Kingston Parish Council
Mrs V Knight
33 The Ridings
East Preston
West Sussex
BN16 2TW

Demolition of existing dwelling & erection of 1 No. dwelling, associated landscaping & parking (resubmission following K/11/16/PL).
Spring Tide Gorse Avenue East Preston

Thank you for your internet comments made on 25th February 2019 which has been recorded as **'an objection'** with the comments as follows:

Drawing: Proposed North Elevation
Dwg No: 247-D-12-REV-A

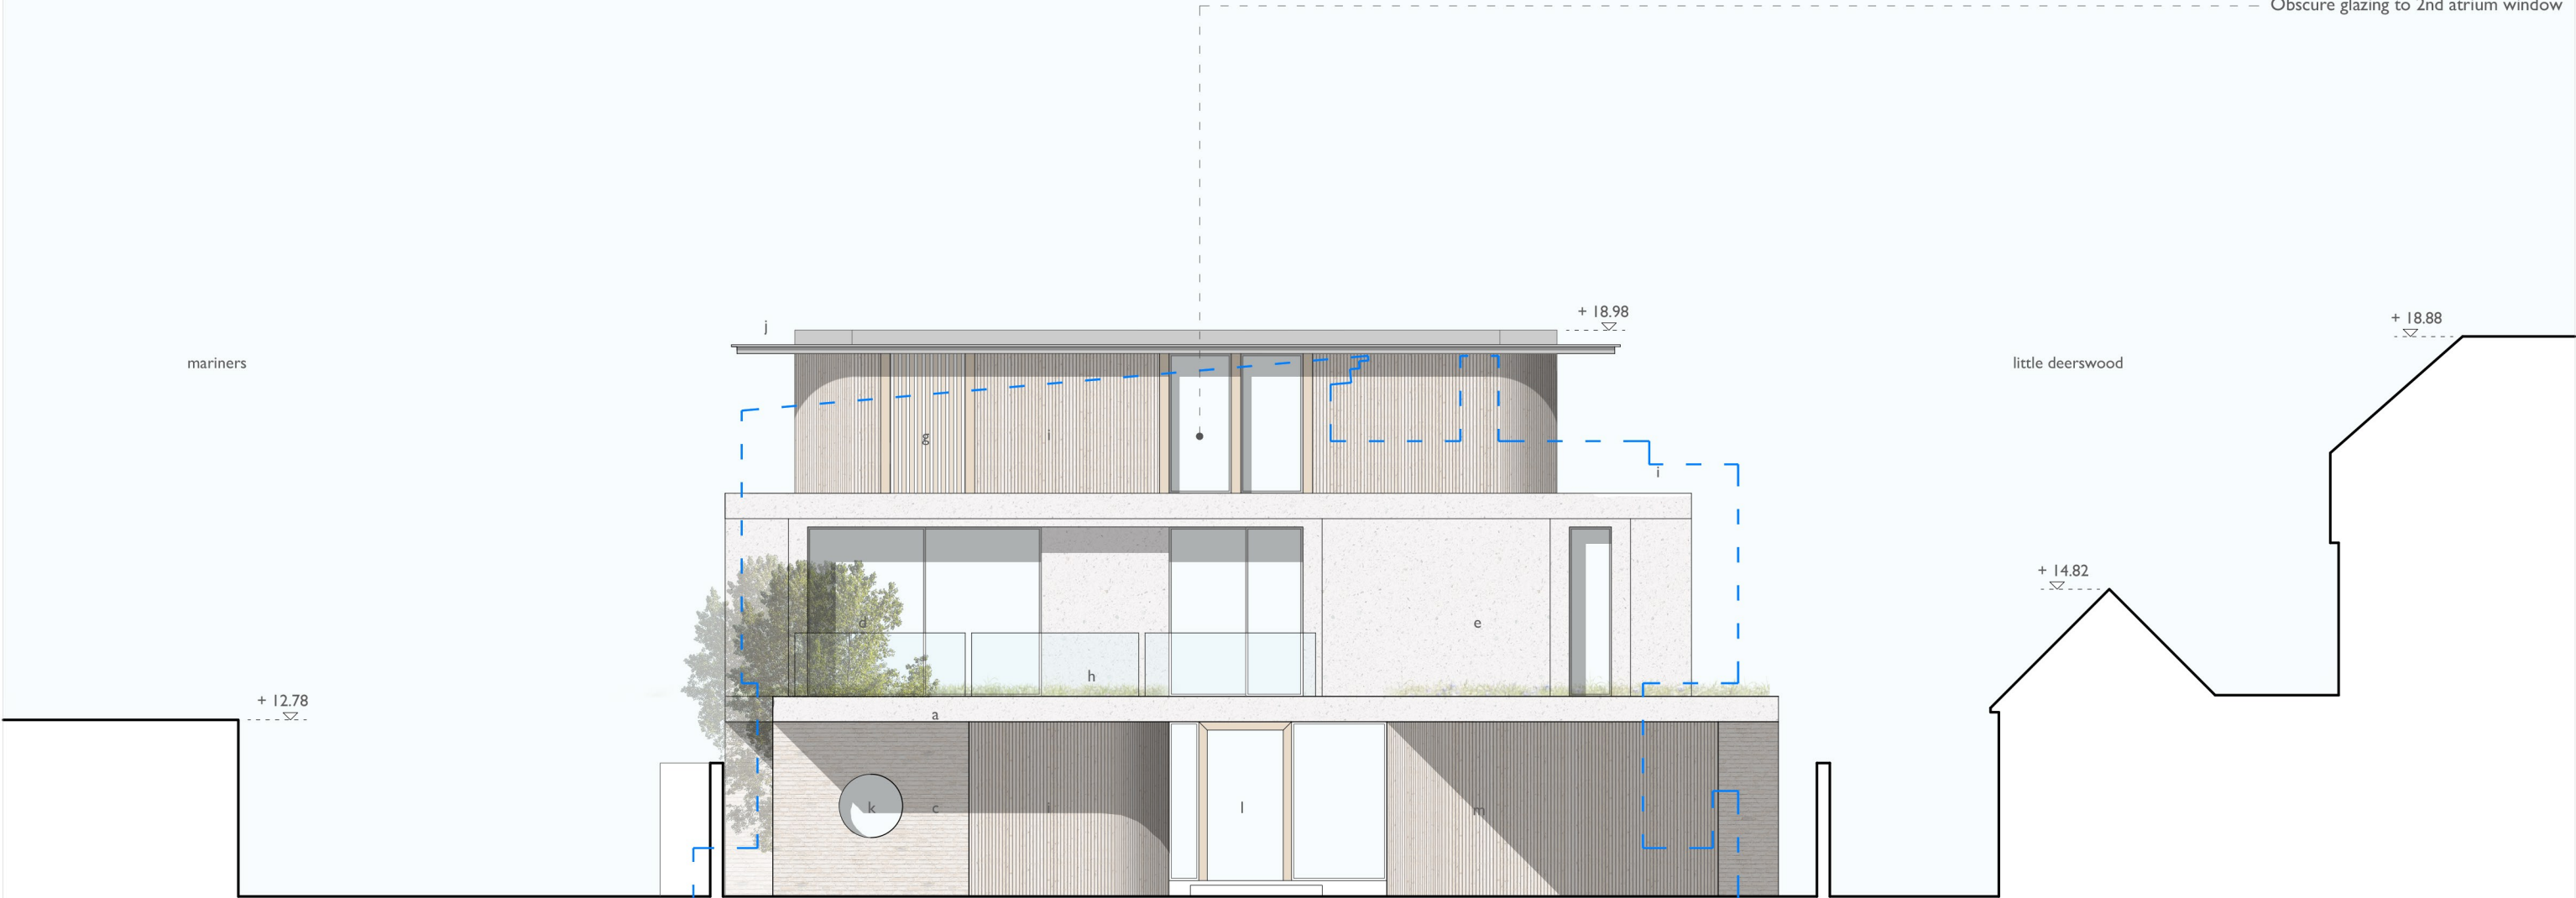
- 5. Council is concerned that it is intrusive to the privacy of neighbouring properties - balconies and the external staircase should have privacy screening to the side and*

overlooking windows should be fitted with opaque glass.
